Our Ref: AW/264/19/HH
Your Ref:

Town & Country Planning Act 1990 (as amended)
Town & Country Planning (Development Management Procedure) (England) Order 2015
Application for Planning Permission for Works or Extension to a Dwelling

Development Removal of existing conservatory and erection of single storey side extension.
Location 7 Kenlegh Aldwick Fields

sheet 2 a of 3

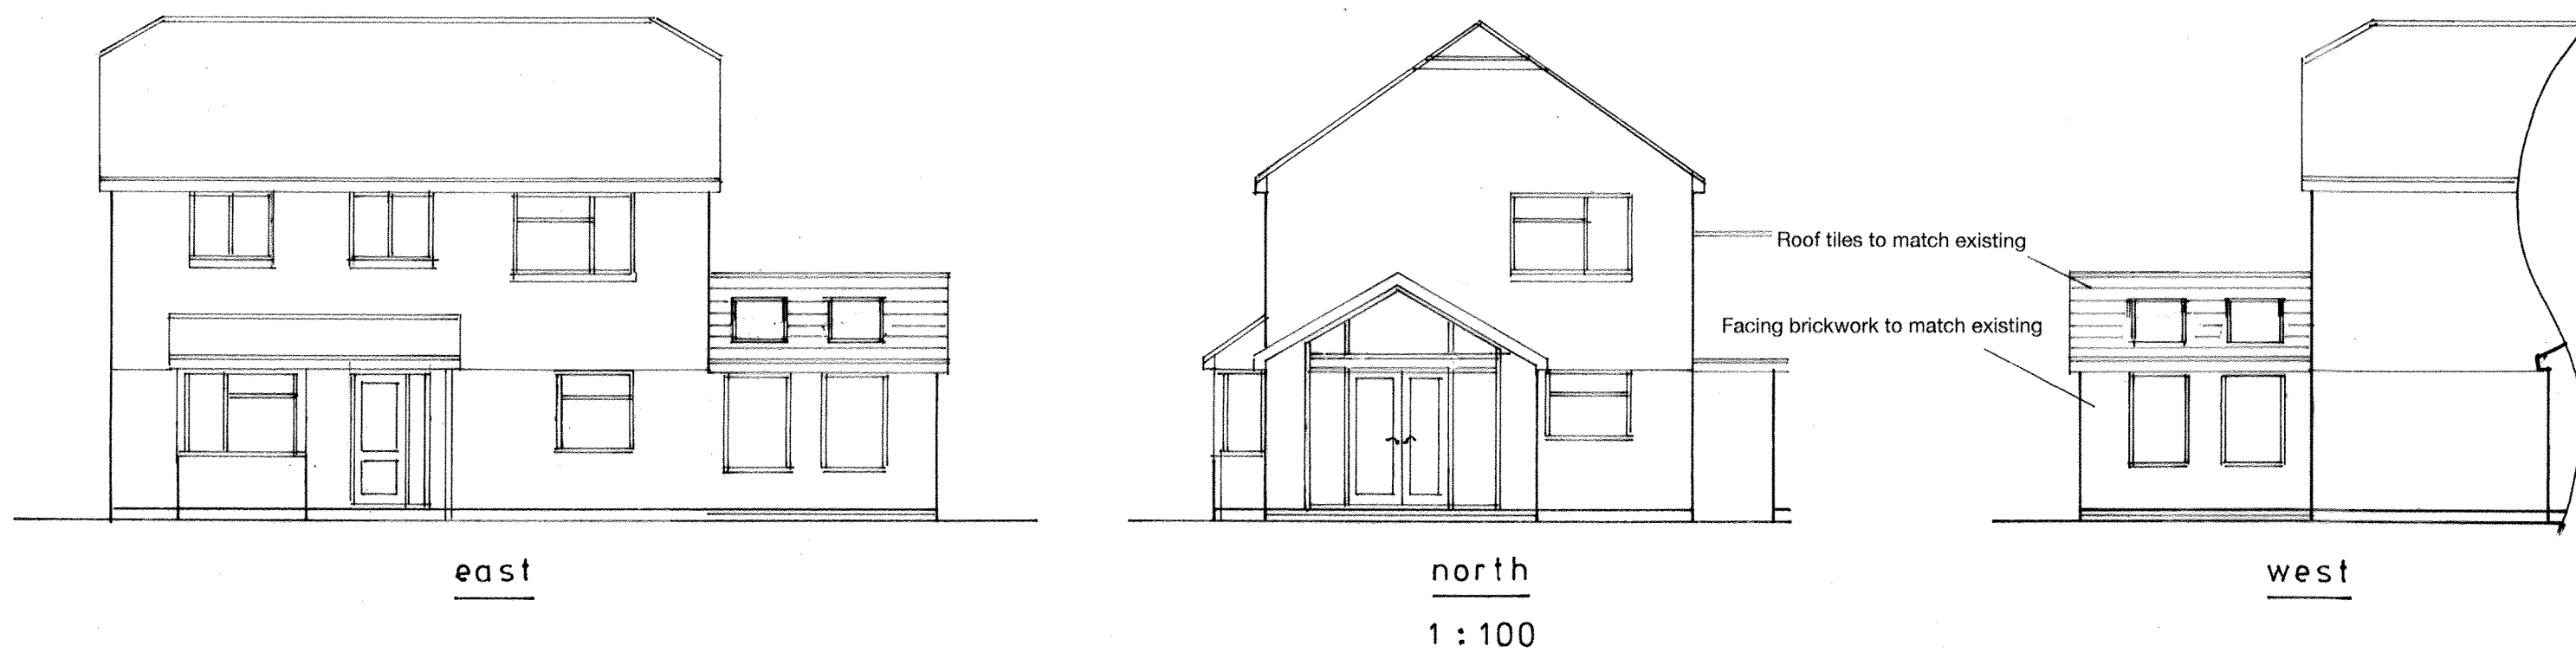
The east and west existing and proposed elevations have been labelled incorrectly. Please amend and re submit.
